Re: Portland Taco Bell

My engineering colleagues have provided the detailed comments below as to what needs to be revised/added on the CONCEPT plan (as attached) so that it can provide the basis for the amendment application:

"NO LEFT TURN" SIGN

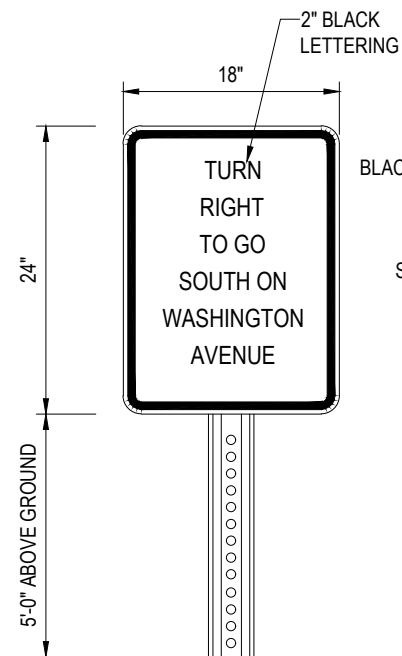
- At exit at Washington: "NO LEFT TURN" (the detail of sign shown on the plan was not reviewed)
- At beginning of the rear exit connector where dumpster is located (dumpster needs to be moved south): one sign with arrow left saying "TO DRIVE THROUGH" and arrow right saying "EXIT HERE FOR WASHINGTON AVENUE"
- Where the connector leaves the Taco Bell site at property line: "TURN RIGHT TO GO SOUTH ON WASHINGTON AVENUE"
- At drive-through exit just before crosswalk at front: "GO TO REAR EXIT TO GO SOUTH ON WASHINGTON AVENUE"
- On Washington Avenue directly opposite the exit lane of the site driveway, in the esplanade between the street and sidewalk: a post-mounted "NO LEFT TURN" sign.

CONCEPT PLAN

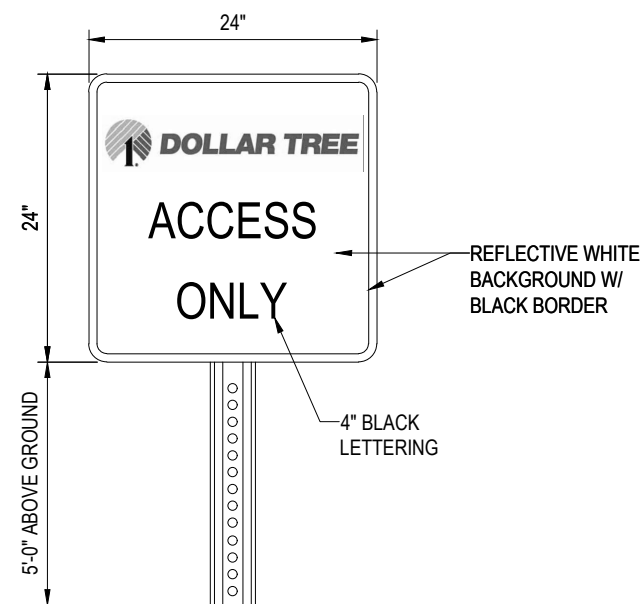
- At exit on Washington: large arrow curving to right with words "RIGHT TURN ONLY"
- Near where exit connector starts: double arrow, one towards drive-through and one towards exit (possible labels?)

- Move trash enclosure south or next to its original location so that the new exit and associated signage is clearly visible and obvious

- Add landscaping (prefer trees) both sides of trash enclosure (wherever its located) but avoiding encroachment on exit connector/drive aisles (this would be a discussion item during the review once the layout is final)
- Remove the 5 parking spaces (and striped bumpout) that were added alongside the drive-through, as a passing lane for the drive-through is needed. This might allow the trash enclosure (if smaller as per existing) to be located in back north corner and thus restore the lost parking space
- Please provide details of the new exit drive retaining walls and railings (this can be during the review).
